Morrisons 43-67 High Street, Yiewsley

Design and Access Statement Addendum- November 2018

2370/APP/2018/2793 Application

Amended Planning Drawings

Drawing Title
Proposed Rear Elevations

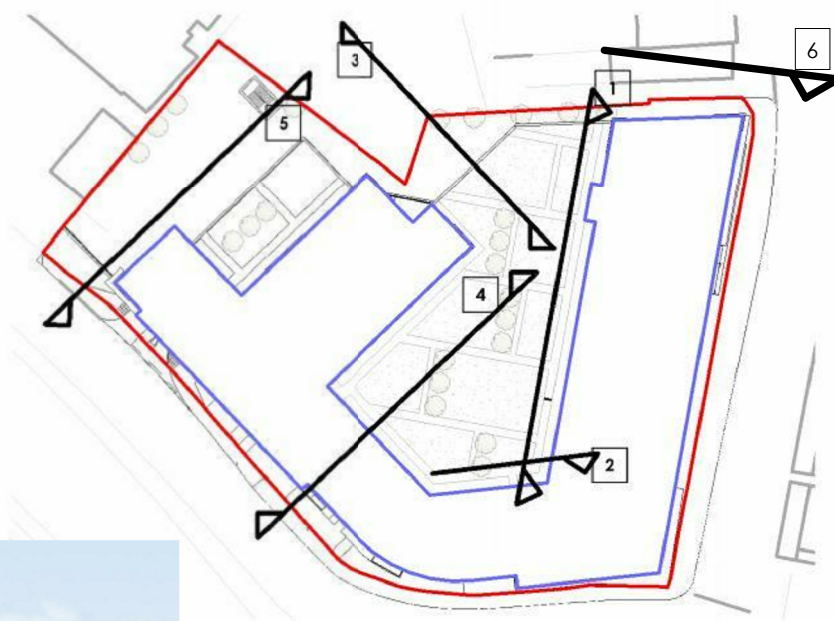
Additionally we have removed the inset balconies that face the school at levels 3 to 6 so that any perception of overlooking the school playground is removed.

Drawing Title
Proposed Sections

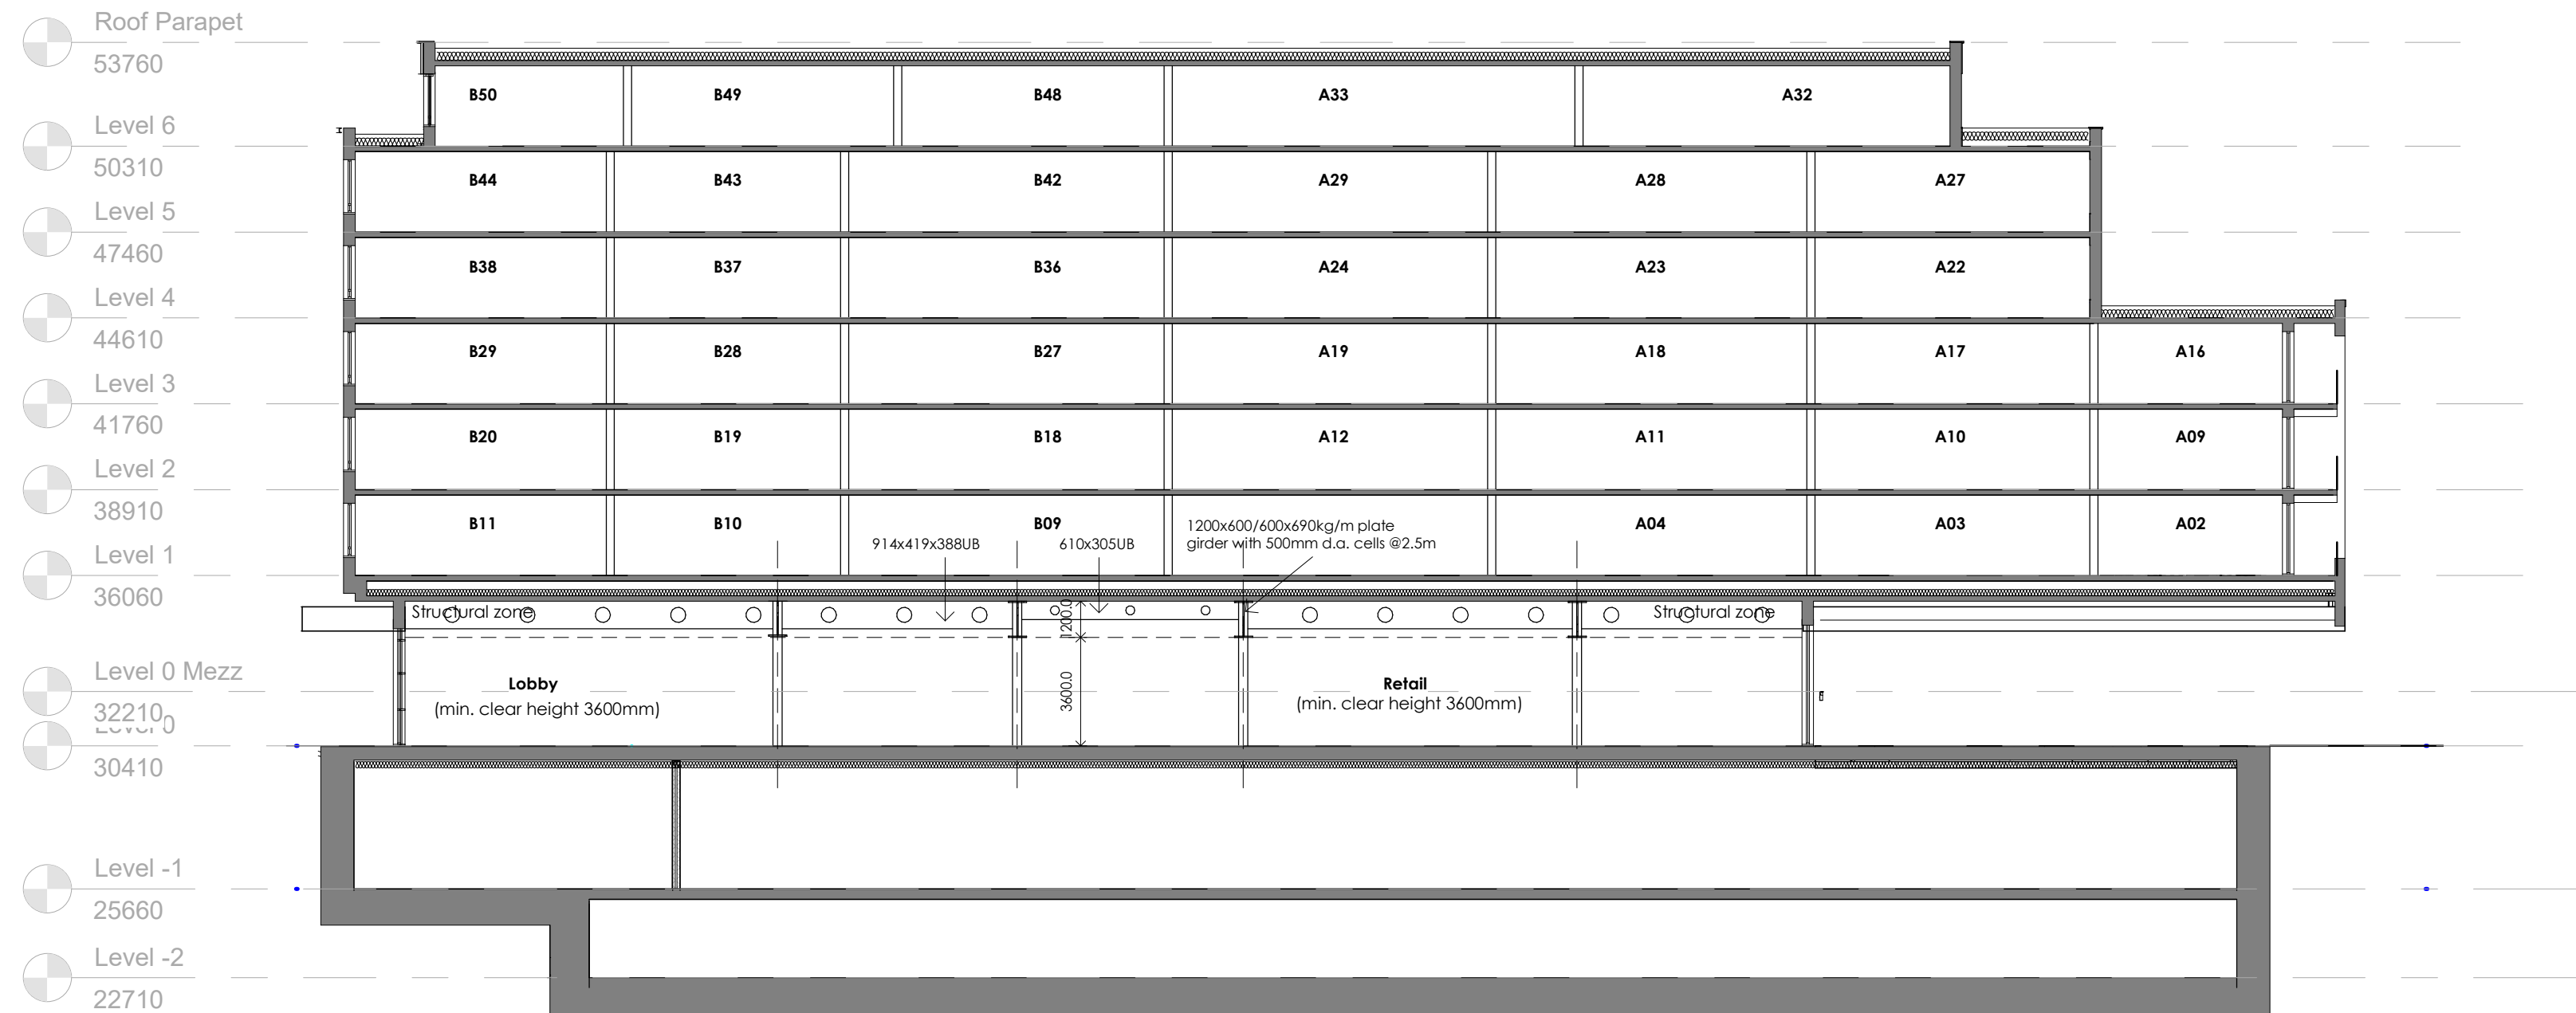
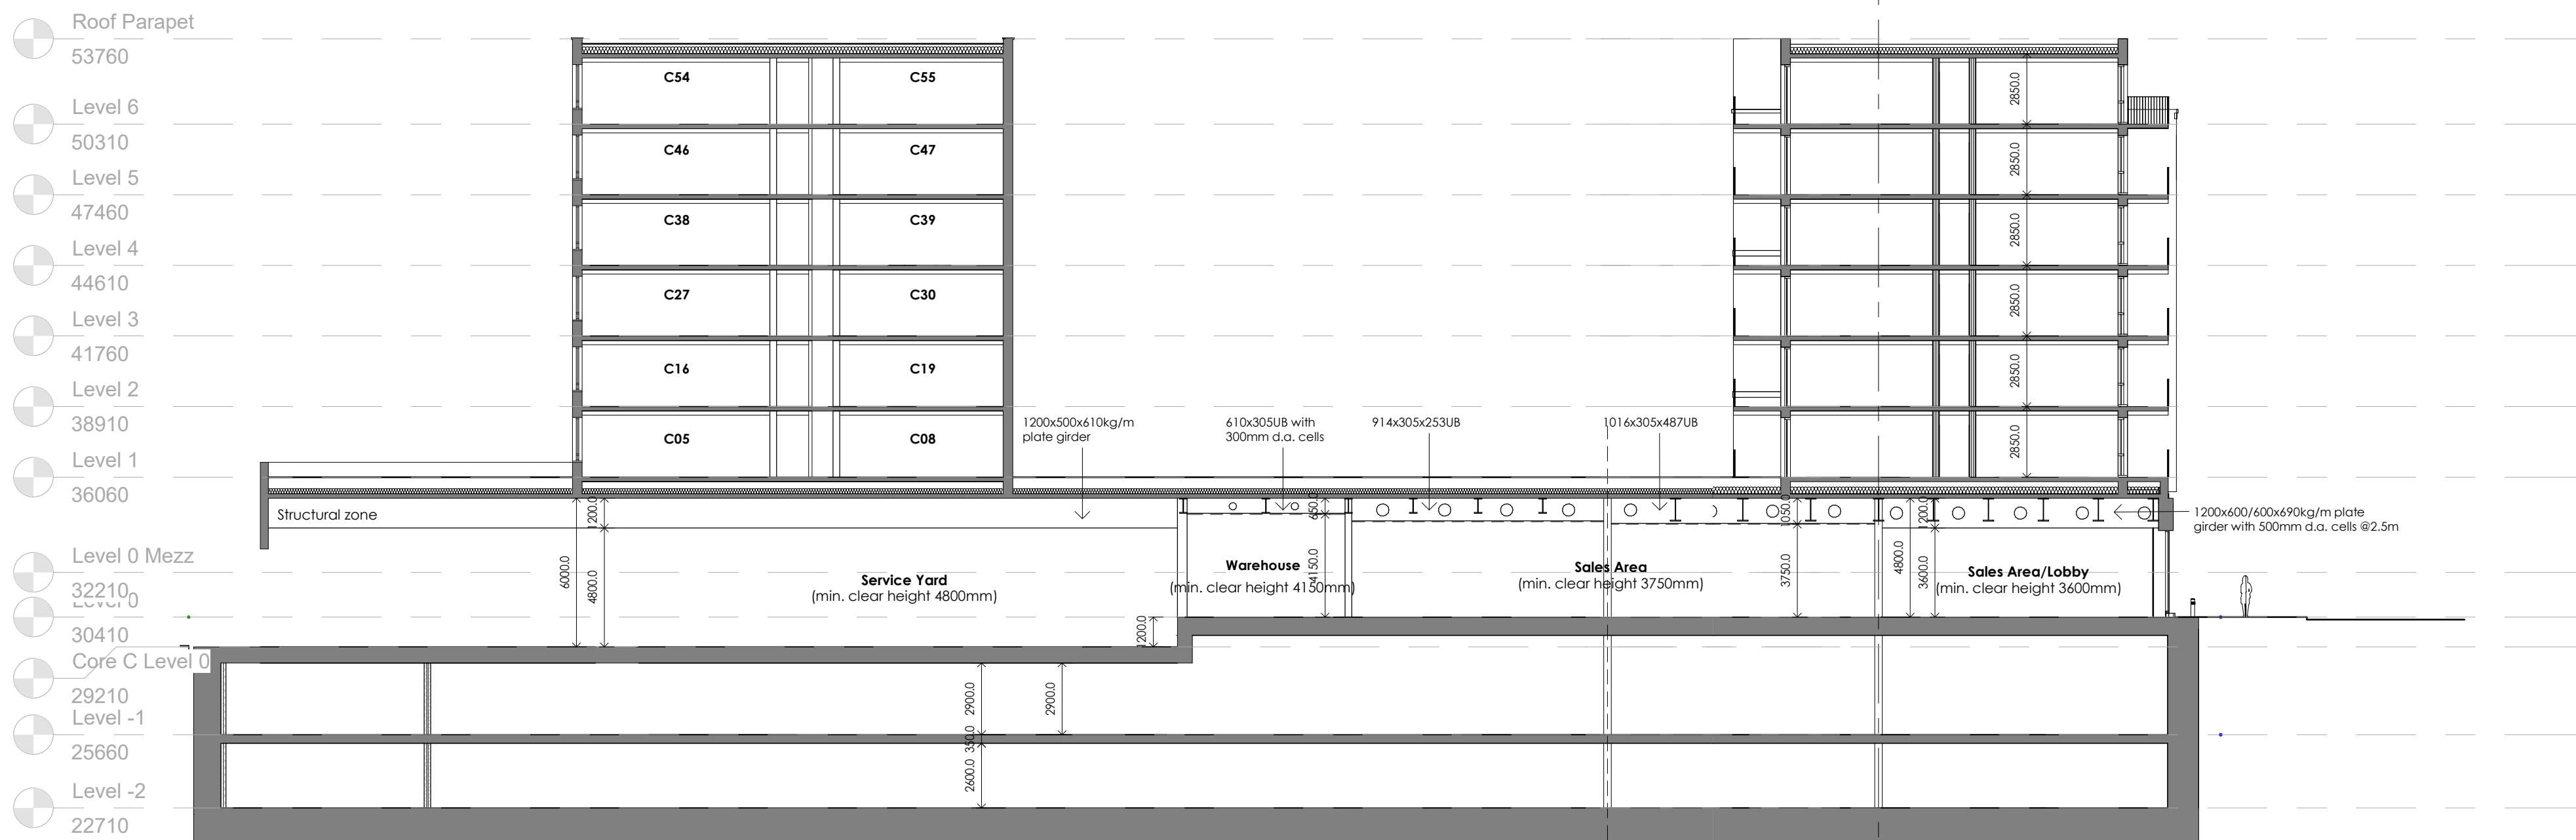
Since the application (2370/APP/2018/2793) was submitted in July, significant work has gone into decreasing the overall height of the building.

The perception of height has been reduced from both the High Street and the Grand Union Canal, by inseting the top floor and reducing the structural heights of each floor.
